## REQUEST

Proposed Zoning: O-2(CD) LLWPA SPA (office, conditional, Lower Lake Wylie Protected Area, site plan amendment), NS LLWPA SPA (neighborhood services, Lower Lake Wylie Protected Area, site plan amendment)

Approximately 15.48 acres located along Steele Creek Road between Interstate 485 and Outlets Boulevard.

The petition proposes to amend a previously approved plan to allow an additional drive-thru lane, alter the O-2(CD) building envelopes, and change the zoning of a small parcel on the southern corner of the site from O-2(CD) to NS.

P:\DWG\018-574-002 STEELE CREEK LANDING REZONING PLANR2A - 12.21.22.DWG TECH DATA SHEET 24X36 12/22/2022 2:50:10 PM LANIER-LT.CTB MGRHAM

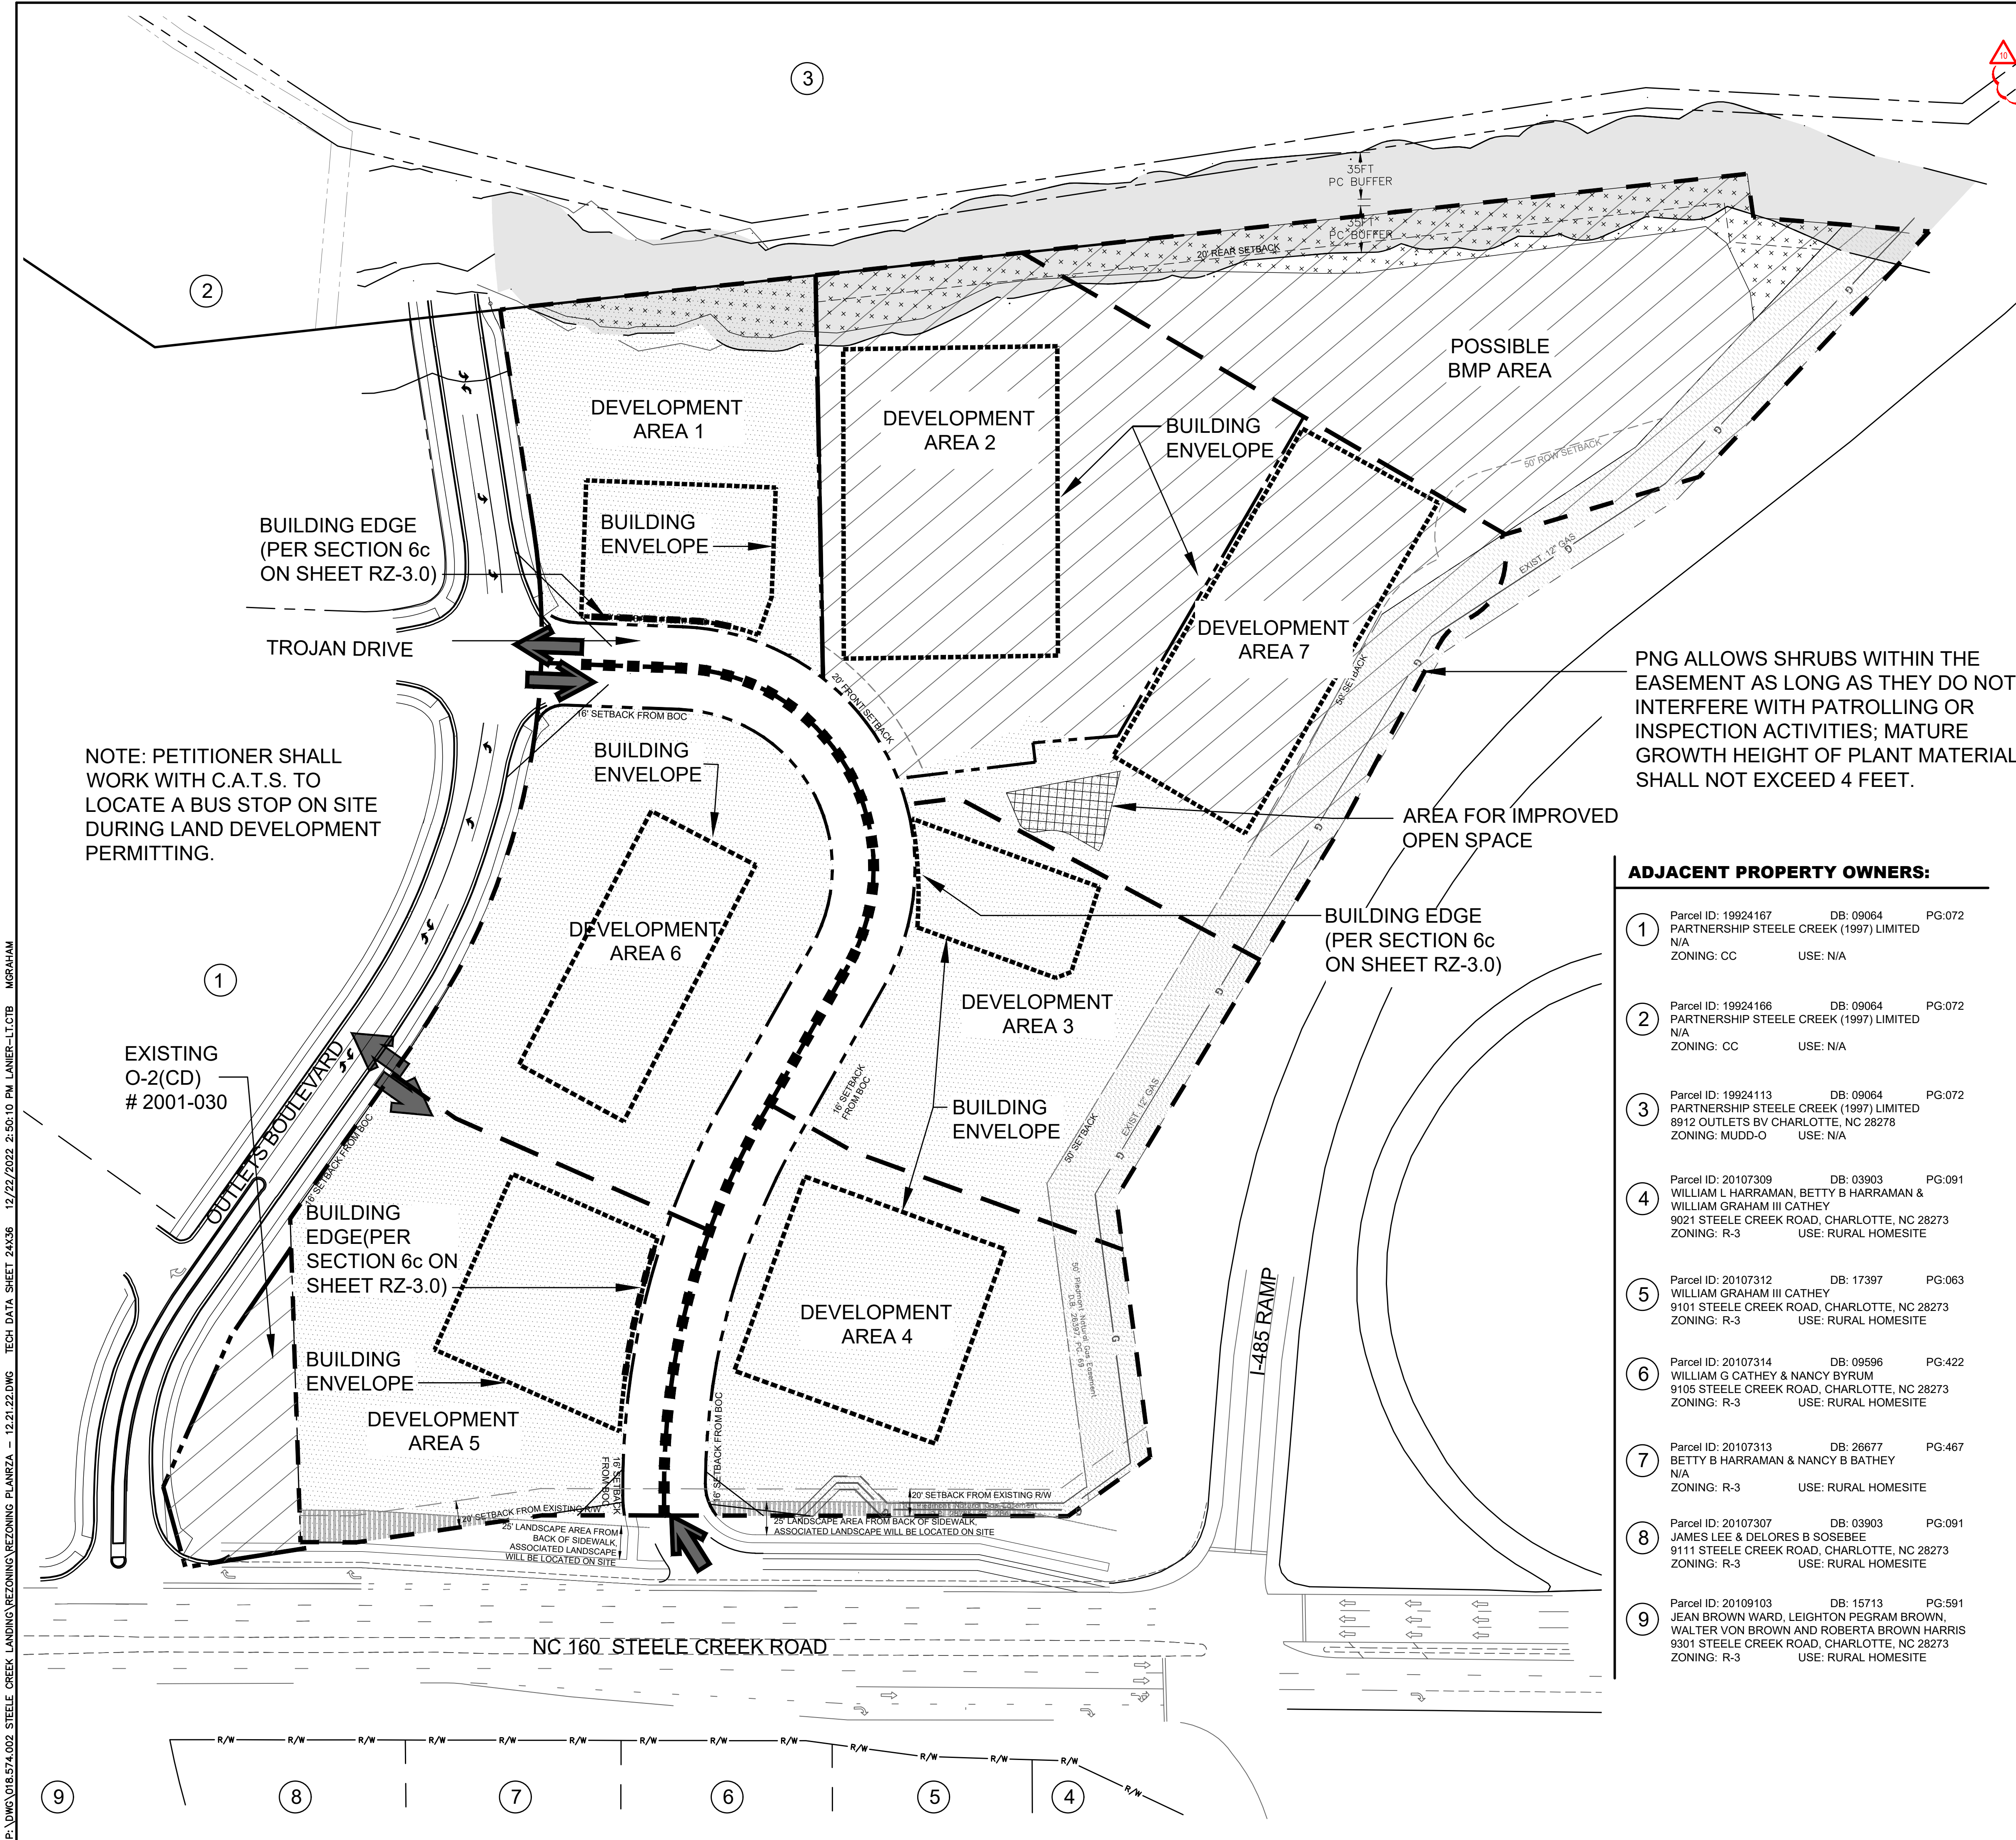
1. Add callout and conditional note for proposed intersection control to be approved by CDOT during permitting at new public street and proposed private drive.
2. Add a conditional note specifying "A Right-of-Way Encroachment Agreement is required for the installation of any non-standard item(s) (irrigation systems, decorative concrete pavement, brick pavers, etc.) within a proposed/existing City-maintained street right-of-way by a private individual, group, business, or homeowner's/business association. An encroachment agreement must be approved by CDOT prior to construction/installation. Contact CDOT for additional information concerning cost, submittal, and liability insurance coverage requirements."
3. Edit conditional note 3.d to add "CDOT requests rights-of-way set at 2' behind back of sidewalk where feasible".

4. Label the width of all potential stream buffers on rezoning plan, including the Undisturbed Watershed Protection Buffer for the Lower Lake Wylie Protected Area. Depending on project density, the Undisturbed Watershed Buffer can vary from 40' to 100' and should be labeled as such on the rezoning plan.
5. Verify that tree save area matches approved plans.

6. Clarify the definition of "business service" as referenced in note 2.e.
-
